Application number: 2020/62/92284/W	
What is the application for?:	Erection of single storey out building to provide home office/studio (within a C
Address of the site or building:	33, Wilshaw Road, Meltham, Holmfirth, HD9 4DZ
Postcode:	OL3 5TN

Type of comment: A general comment
<p>2020/62/92284/W Erection of single storey out building to provide home office/studio (within a Conservation Area) 33, Wilshaw Road, Meltham, HD9 4DZ</p> <p>Dear Sirs</p> <p>With reference to this planning application we do not wish to make a formal objection to this proposal and wish the prospective new owners well. We would simply like to point out a few inaccuracies in the application, make a few constructive suggestions and request that you consider carefully the obvious detrimental impact that this new building will have on the residents of 33A Wilshaw Road (Willow Shae), the adjoining neighbour to No 33.</p> <p>Unfortunately, some of the recent developments on this site have proved very controversial and have not been positive for the Conservation Area and neighbouring properties so, as local residents, we now feel a responsibility to check that no further mistakes are made.</p> <p>1. We note that

PROPOSED NORTH ELEVATION (FACING FIELD) 1:50 @ A2

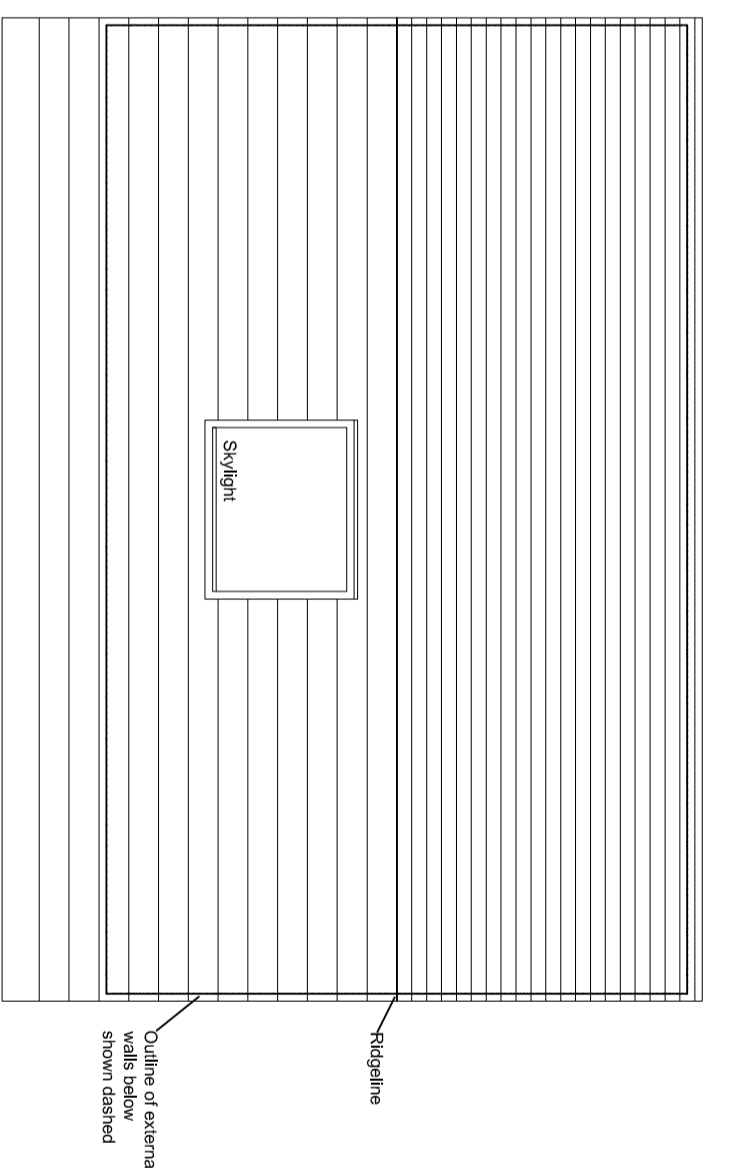
conservation area.

PROPOSED SIDE ELEVATION FACING NEIGHBOURING PROPERTY 1:100 @ A2

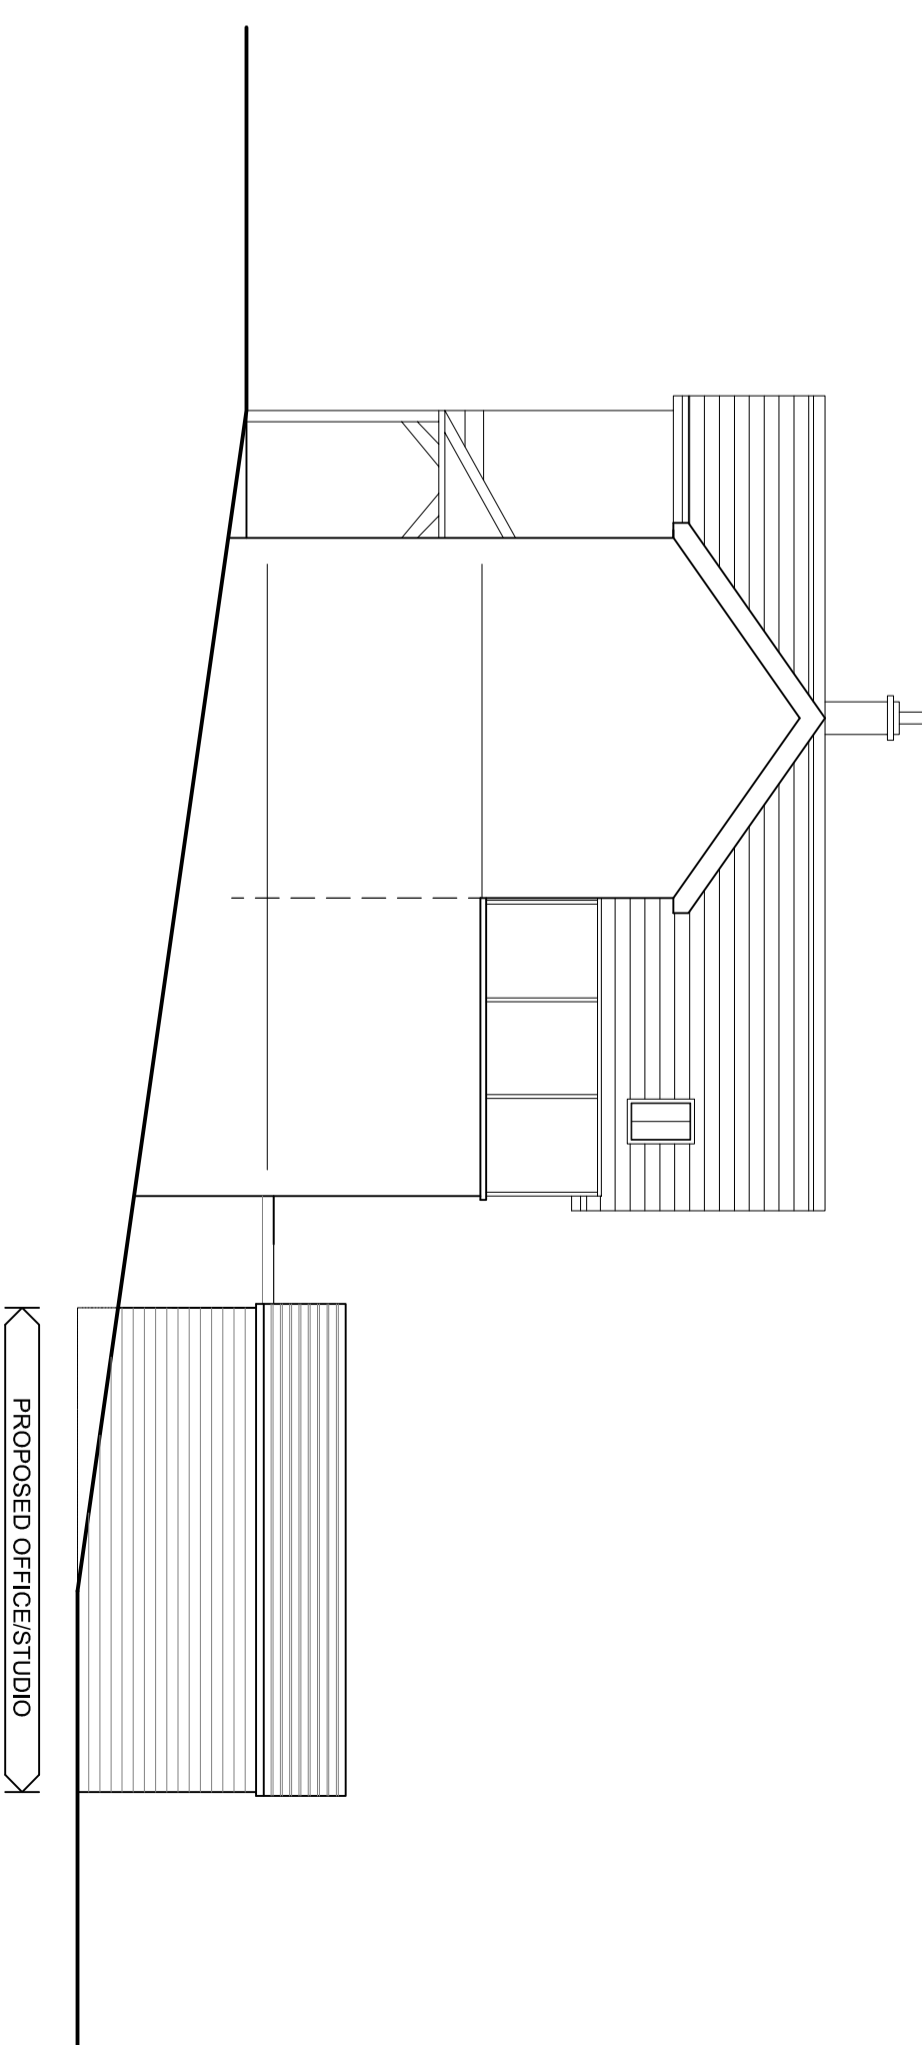
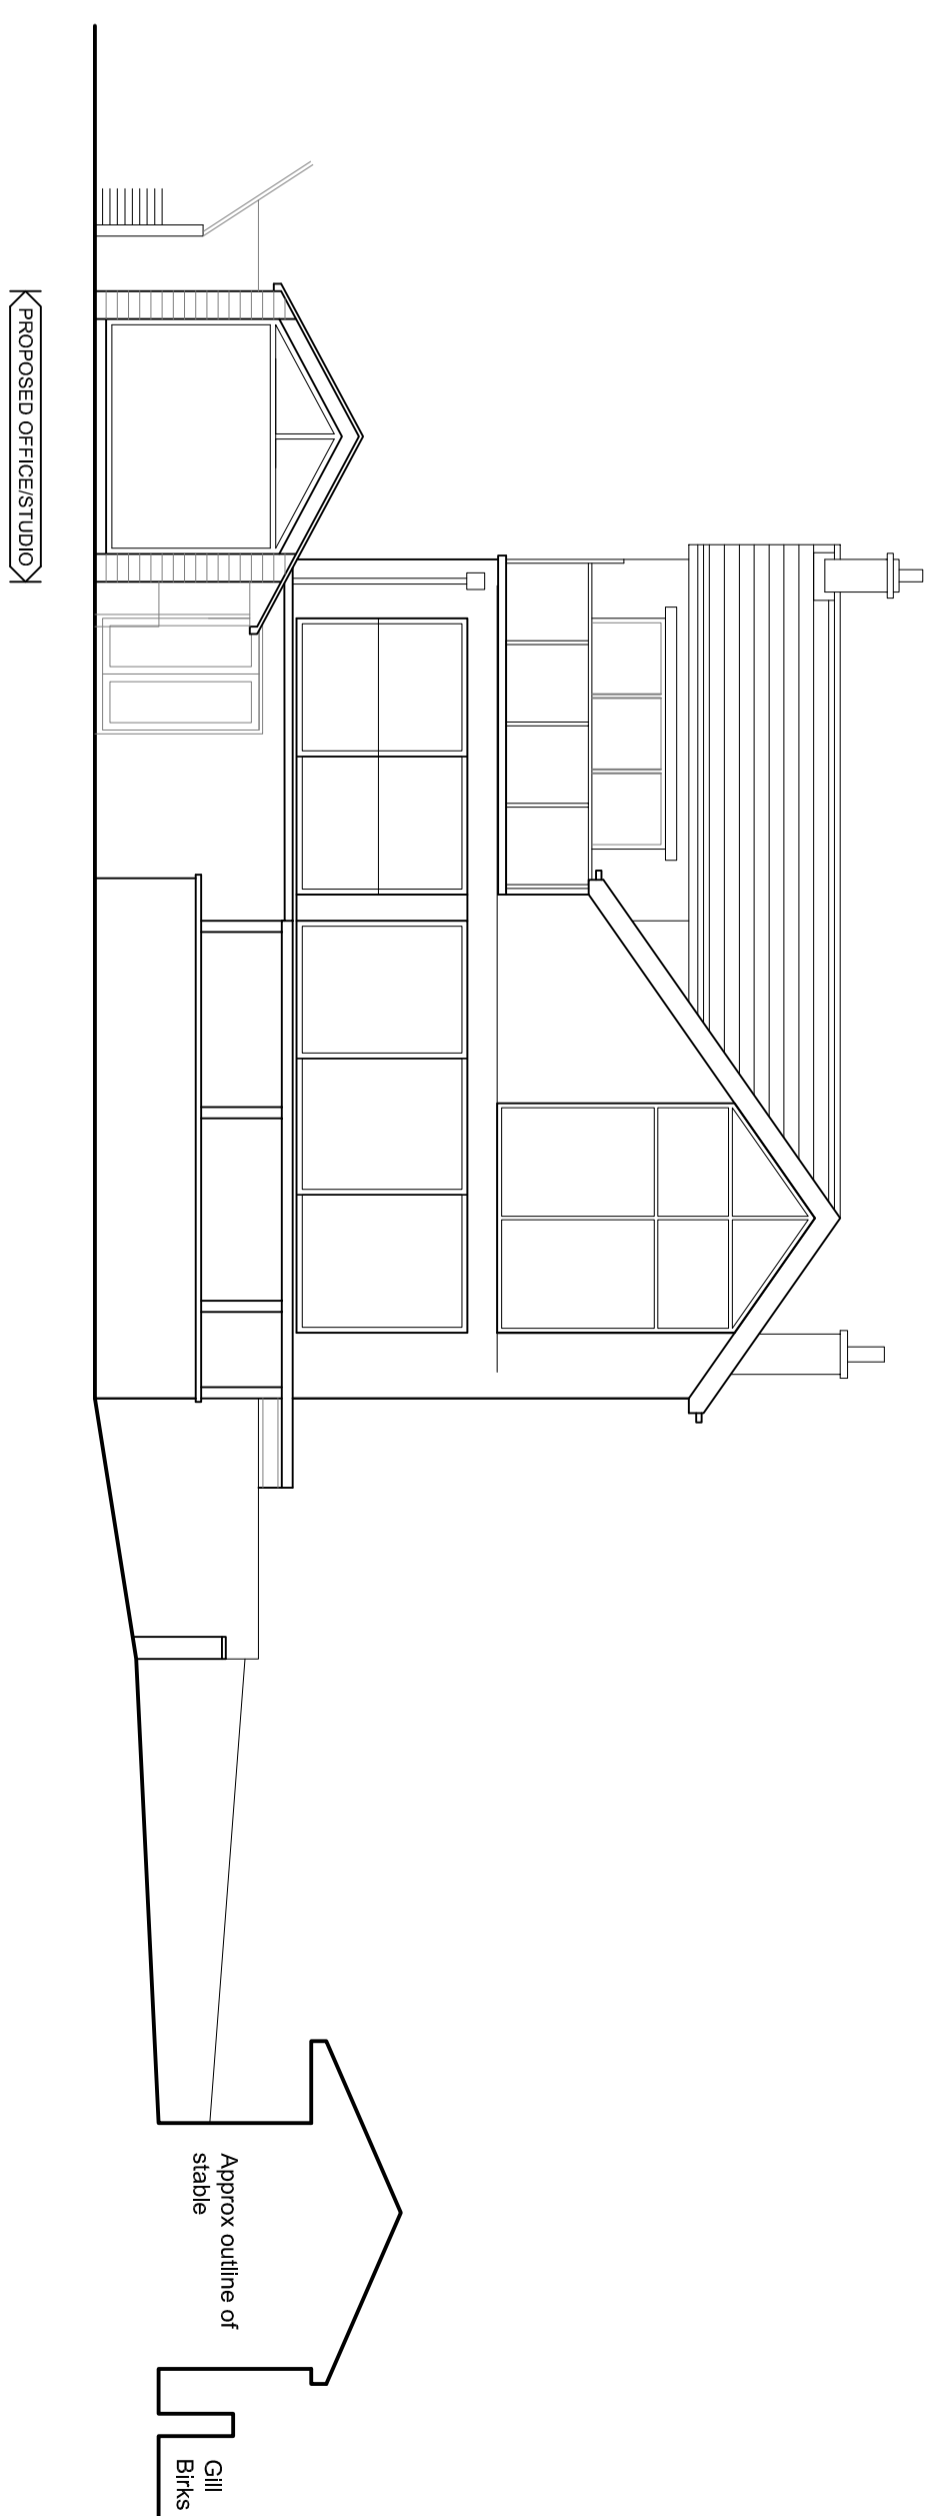
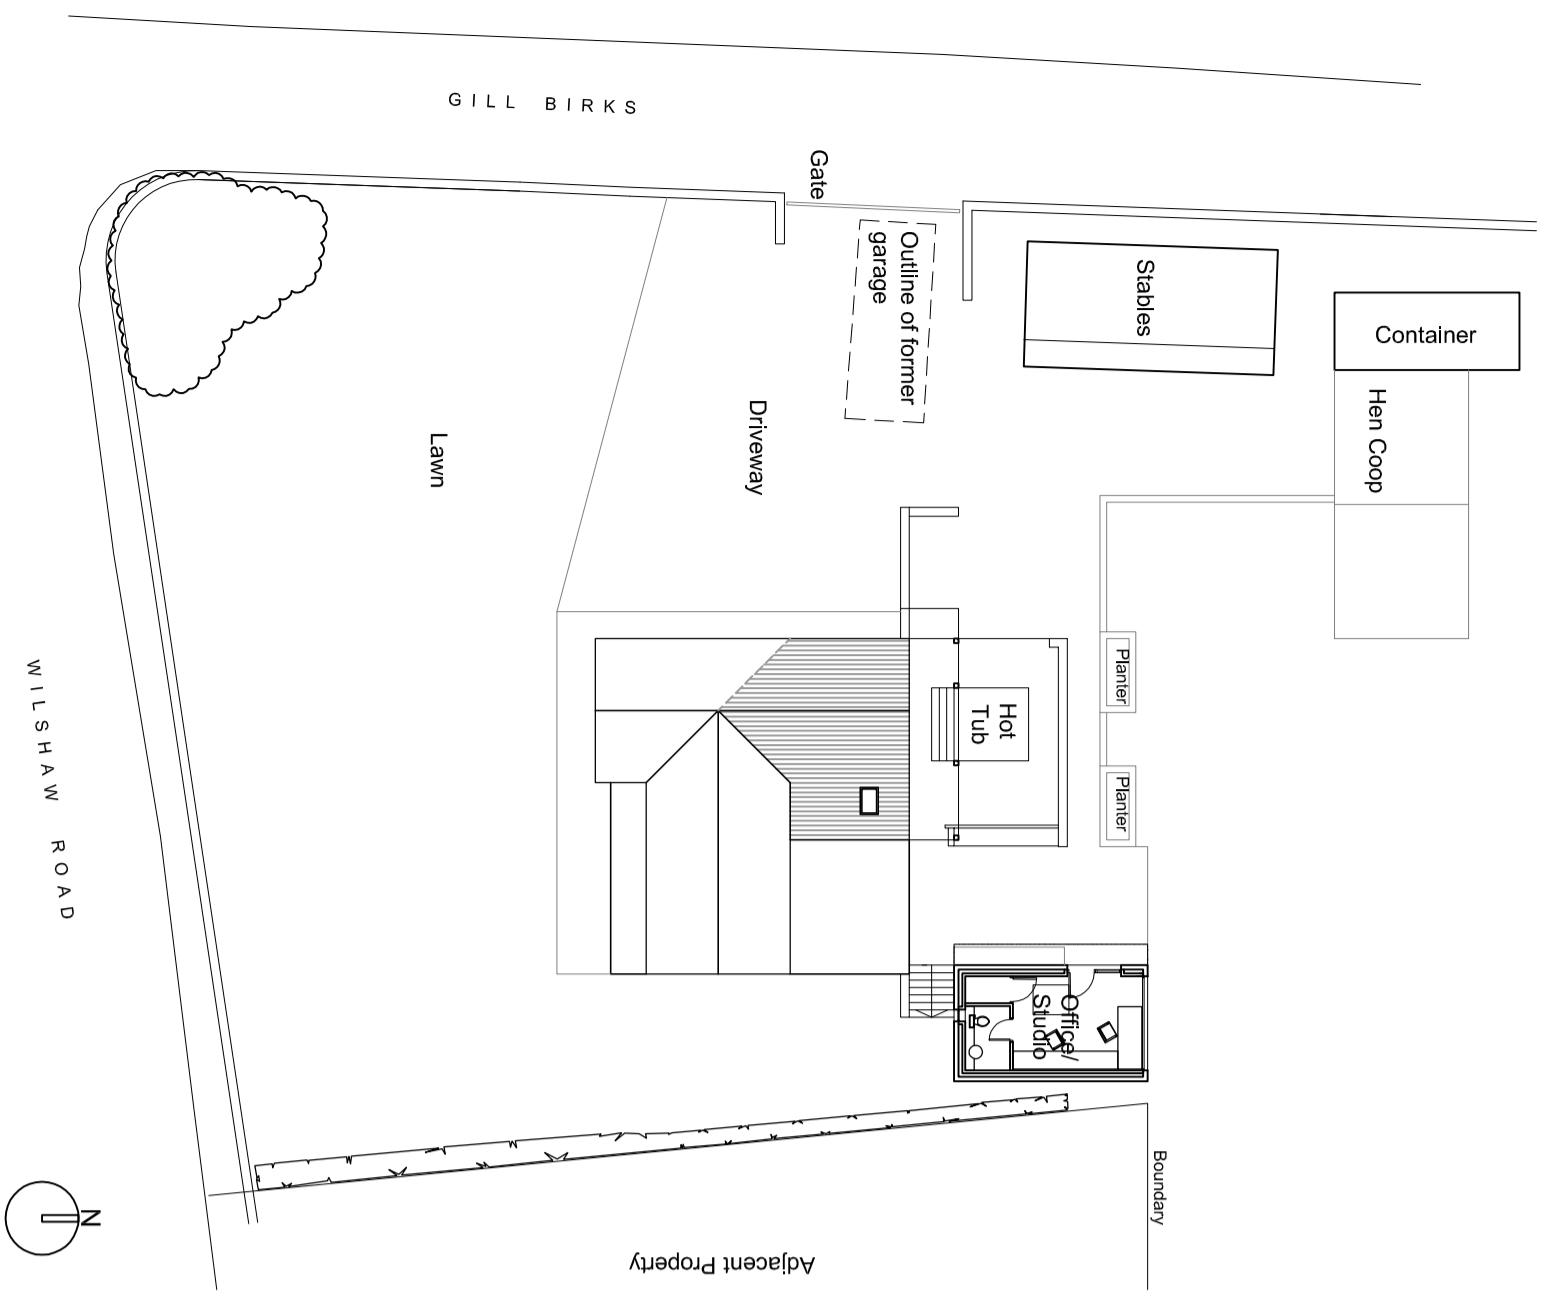
4. The neighbour to the east, 33A Wilshaw Road, has already had the amenity of their occupation of their home seriously, adversely impacted by recent developments on this site. These include the high walls of the extension, the additional walled enclosure and the increase in height of the ground levels that adjoin the rear of their property. The construction of this building, where the applicants want to put it, will almost certainly cause additional harm to the residents of 33A Wilshaw Road and this does not seem fair. So, if this application has to be approved, the building should be positioned as low as possible and as far away from 33A Wilshaw Road's boundary as possible but within 33 Wilshaw Road's domestic curtilage so as to minimise any further negative impact.
